**PERMIT NUMBER**  
**BCOM2410-0005**

Description: **Mavis Tires and Brakes**

Type: **BUILDING COMMERCIAL**

A-603

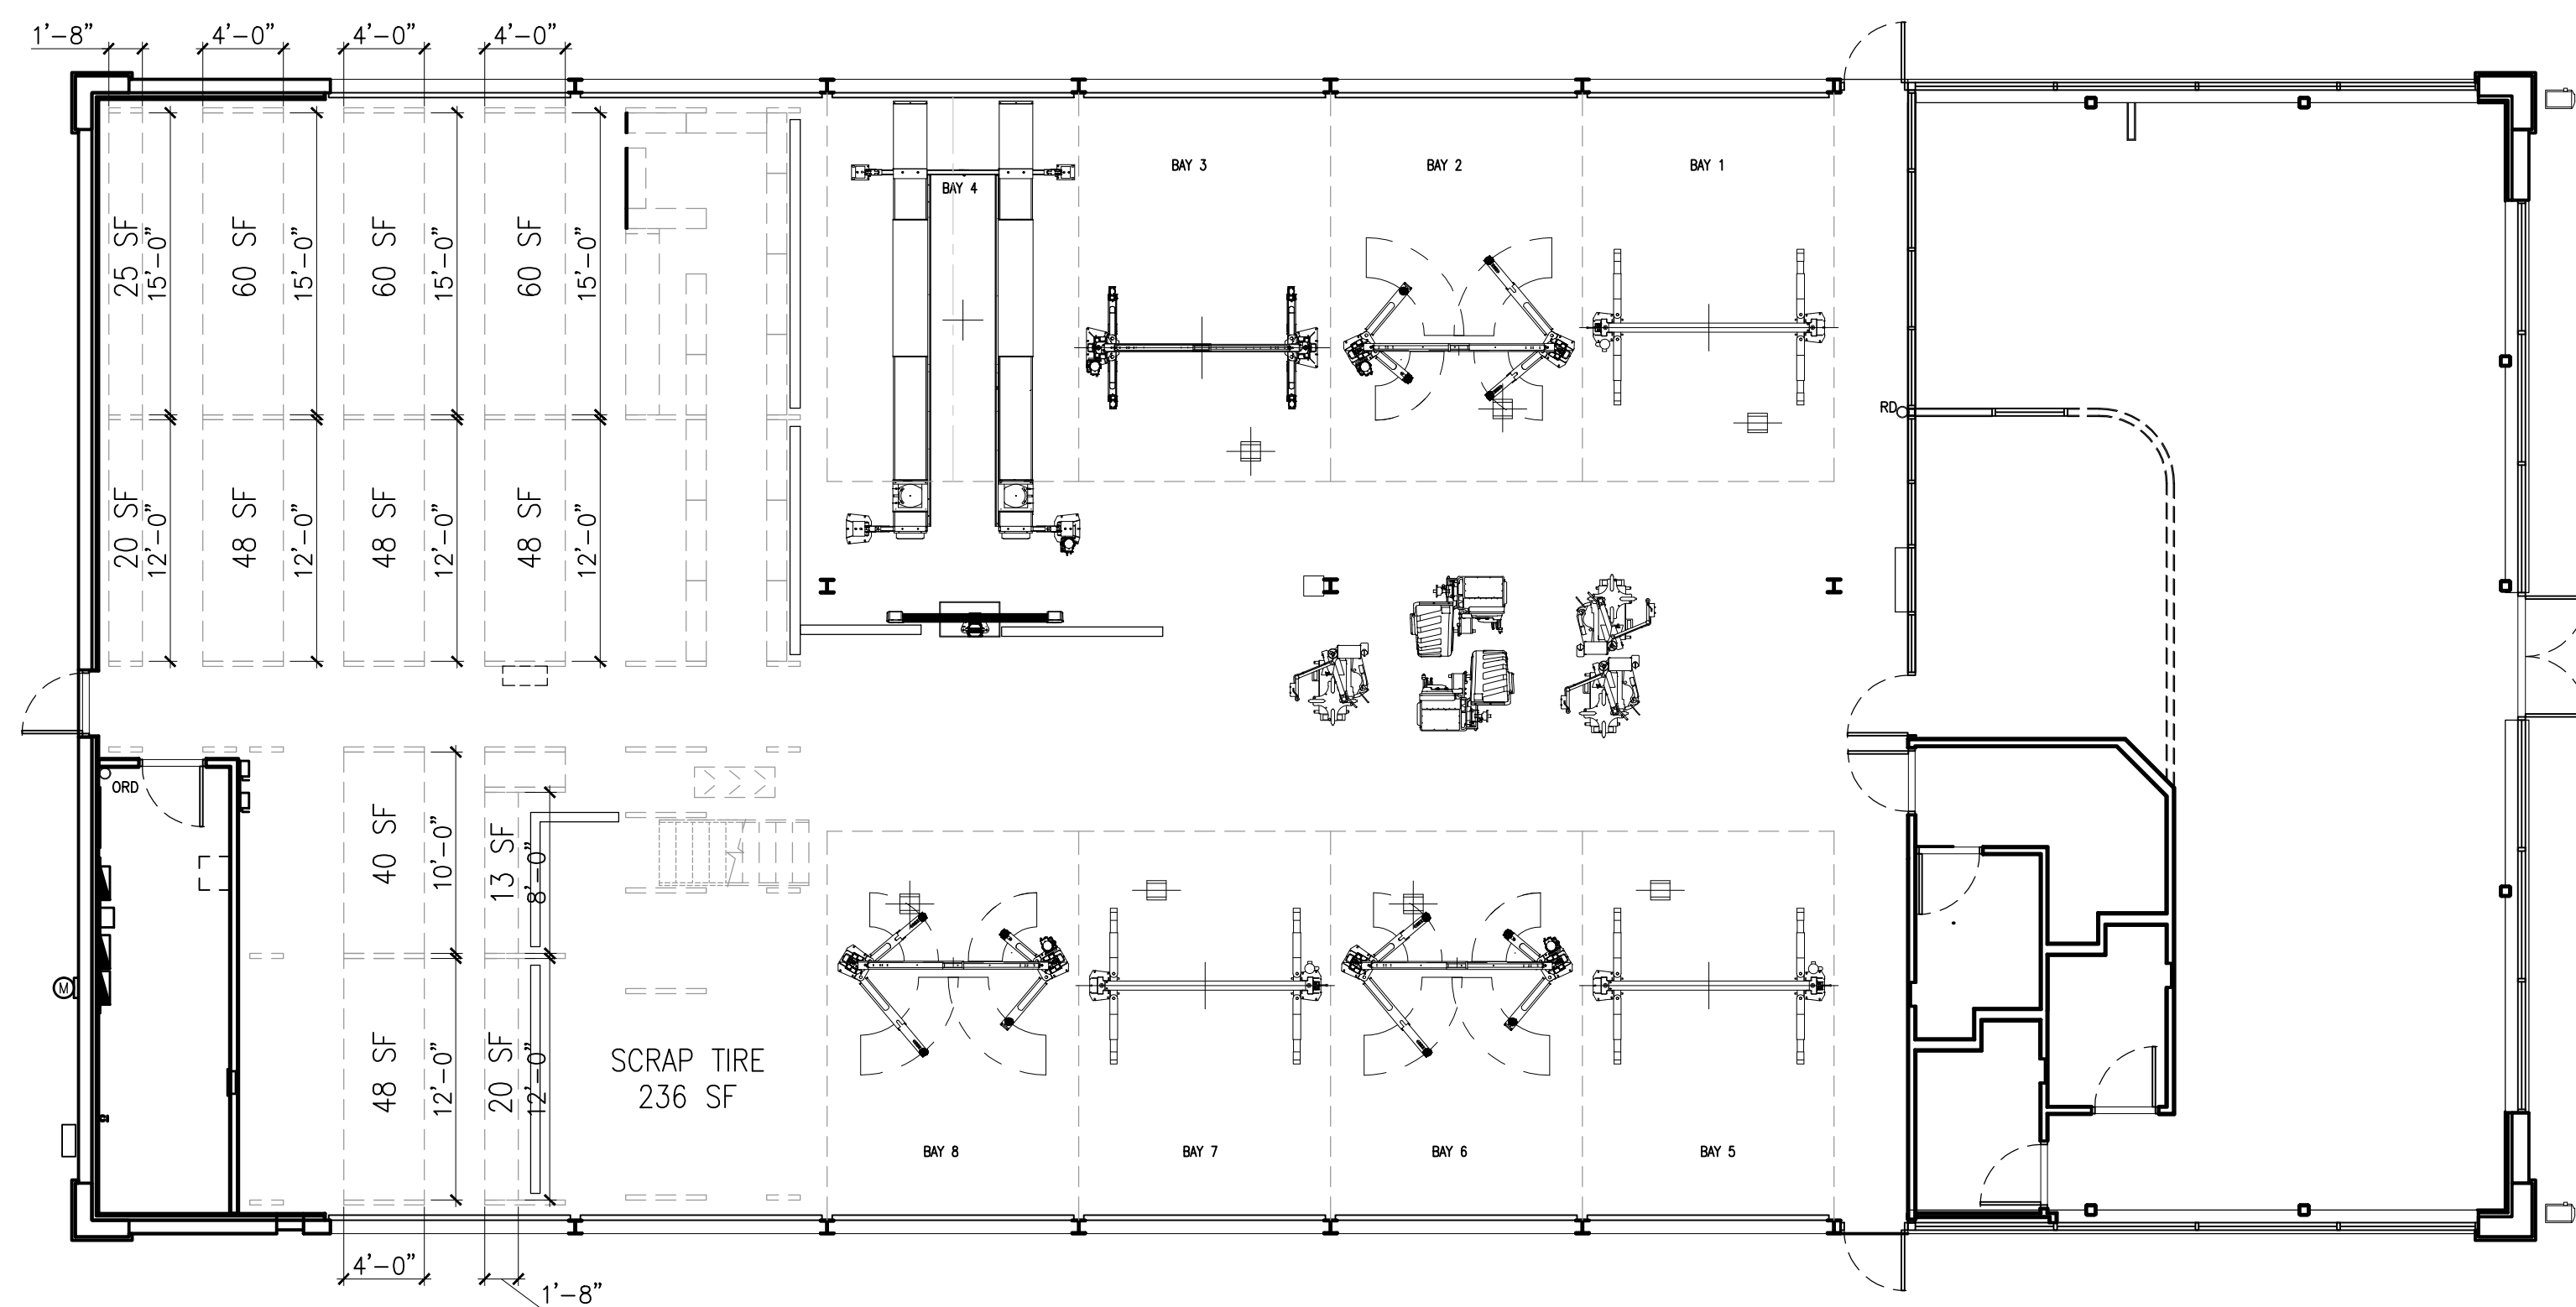
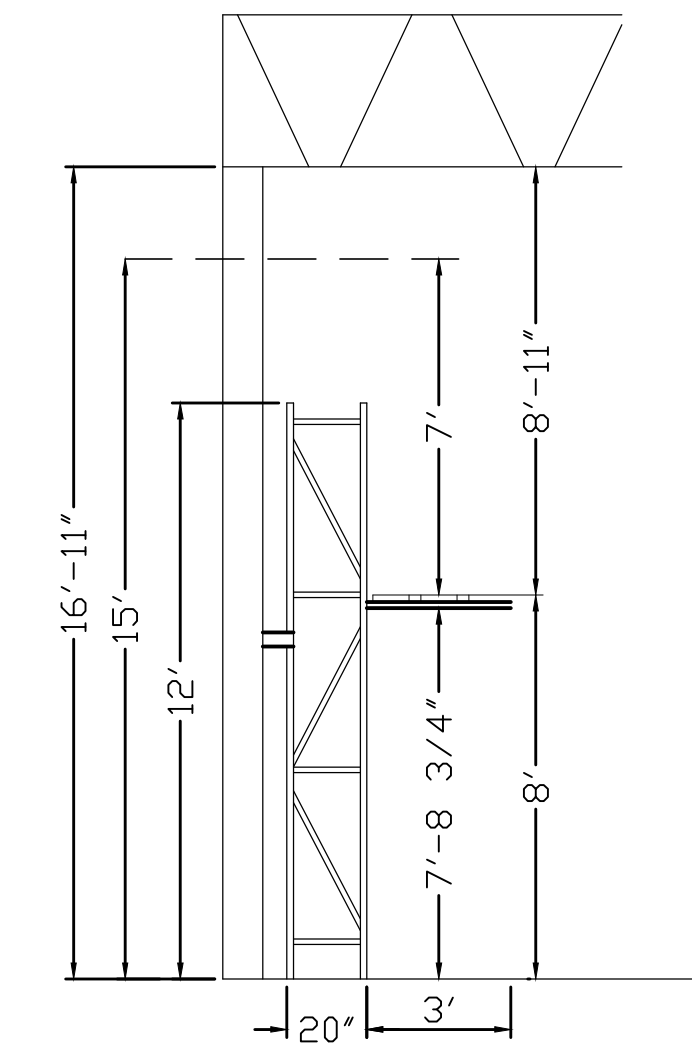
REVIEW TYPE	REVIEWER	SENT DATE	DUE DATE	RETURNED DATE	STATUS	REMARKS	NOTES
COMMERCIAL INTAKE	CP Bucket	10/16/2024		6/10/2025	DISAPPROVED	SITE2410-0001	
COMMERCIAL BUILDING REVIEW	Brad Sutton	12/10/2024	12/24/2024	12/23/2024	DISAPPROVED		Need a specific detail and area calculations for tire storage area in cubic feet. If it exceeds 20,000 cubic feet, sprinklers will be required throughout the building. 2018 NCBC 903.2.9.2
FIRE MARSHAL	Roger Sullivan	12/10/2024	12/24/2024	12/12/2024	APPROVED	see attached letter	See attached letter.
COMMERCIAL BUILDING REVIEW	Brad Sutton	1/16/2025	1/30/2025	1/24/2025	APPROVED		
FIRE MARSHAL	Roger Sullivan	8/20/2025	9/4/2025	8/21/2025	APPROVED	Fire alarm Plans	See attached letter.
